From: Amanda Scholes on behalf of Planning.Responses
Sent: 16 October 2019 08:30
To: Planning Scanning
Subject: FW: White Cottage, Walberton (WA/22/19/PL)

Consultee response

From: Laura Gibbons [REDACTED]
Sent: 15 October 2019 15:53
To: Julia Davies [REDACTED]; Andrew Wood [REDACTED]
Subject: RE: White Cottage, Walberton (WA/22/19/PL)

Pit to be 2 x 1.5 x 0.8m deep

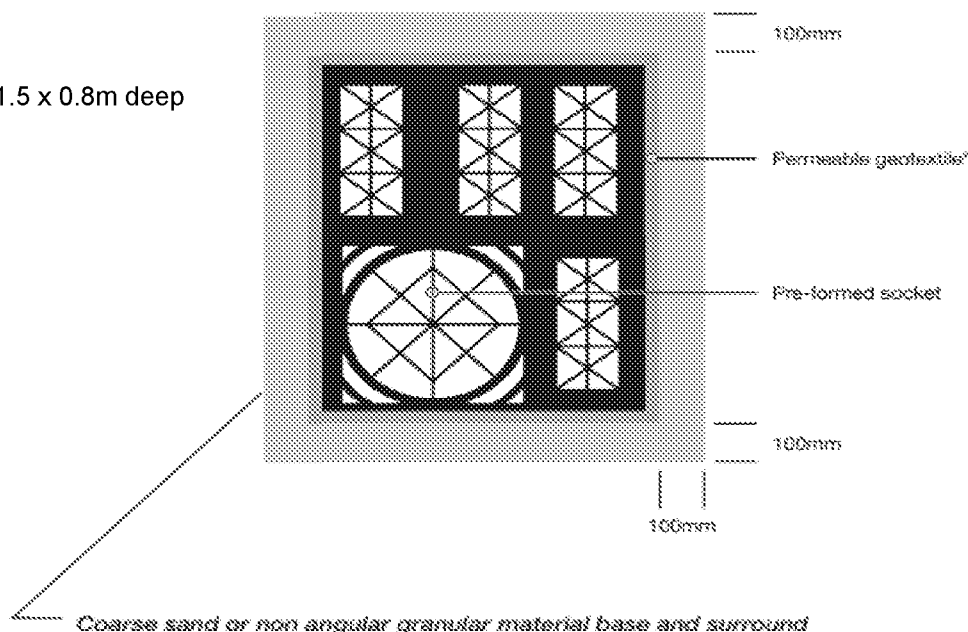
The infiltration test was completed at shallower depths than the proposed infiltrating structures, as a result we require a Factor of Safety of 3 to be used in design.

Please can details of the pipe diameters and falls proposed be provided.

Please provide inspection chambers rather than easy bends.
